From: Brian Banister [REDACTED]
Sent: 11 December 2021 10:33
To: Planning.Responses <Planning.Responses@arun.gov.uk>
Subject: Re: Planning Consultation on: AB/139/21/PL

Thankyou for the consultation. The views of the **Arun District Conservation Area Advisory Panel** are as follows:

Application No: AB/139/21/PL
Registered: 3rd December 2021
Site Address: Crown Yard Car Park River Road Arundel BN18 9JL
Grid Reference: 501841 107019
Description of Works: Storage container in one bay of the Crown Yard car park to store the stalls for the monthly Arundel Farmers Market.. This application affects the character & appearance of the Arundel Conservation Area and is in CIL Zone 2 (Zero Rated) as other development.

Proposed container

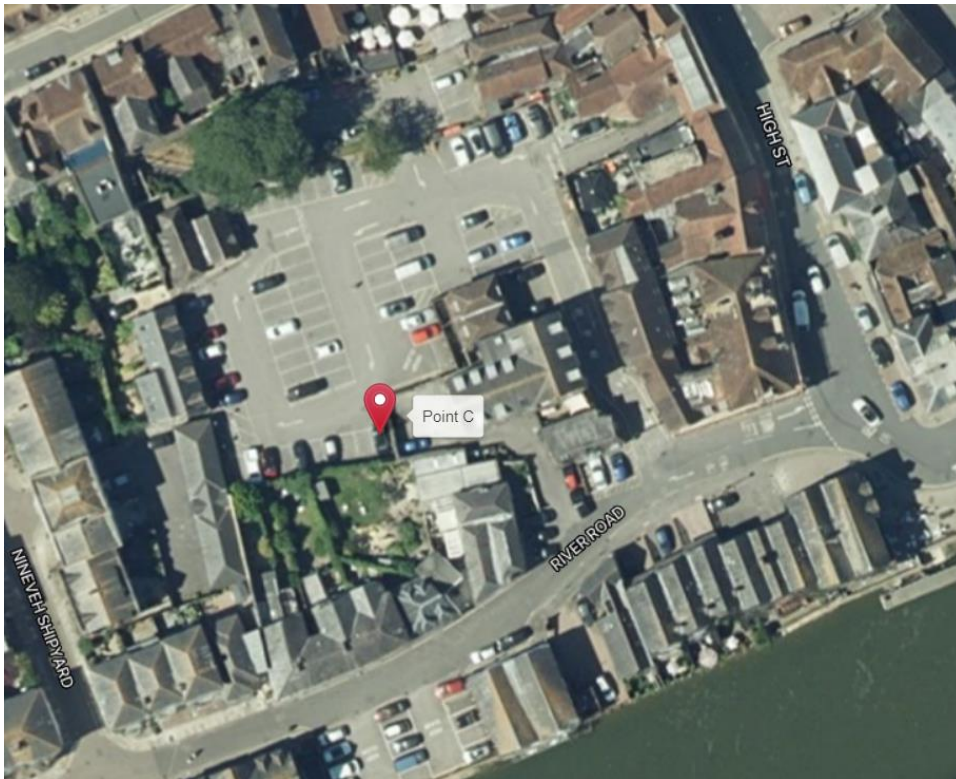
The proposed steel container will be a large, bland, incongruous and visually alien industrial object located in an area of traditional buildings, structures and materials. Although proposed to be sited in a relatively inconspicuous place within the car park, it will detract from the appearance of Crown Yard and, therefore, also the character and appearance of the conservation area.

The Panel are also concerned at the loss of available public car parking space which becomes very limited in the town during busy periods in the summer.

- (1) there is a justified need for a container of this size for the proper running of the Farmers' Market and that it is needed to be located in the town centre,
- (2) it is needed on a temporary basis only until a more permanent and suitably designed storage building can be constructed or facilities found within an existing building in the town centre and that temporary planning permission is granted for the current proposal, say, for an initial period of 3 years and,
- (3) a colour needs to be agreed for the container. No colour is specified in the application and clearly unpainted steel is not appropriate for the historic setting. It is suggested that the structure be painted or coated a dark green which would reduce its visual impact and better relate it to the existing leafy background.
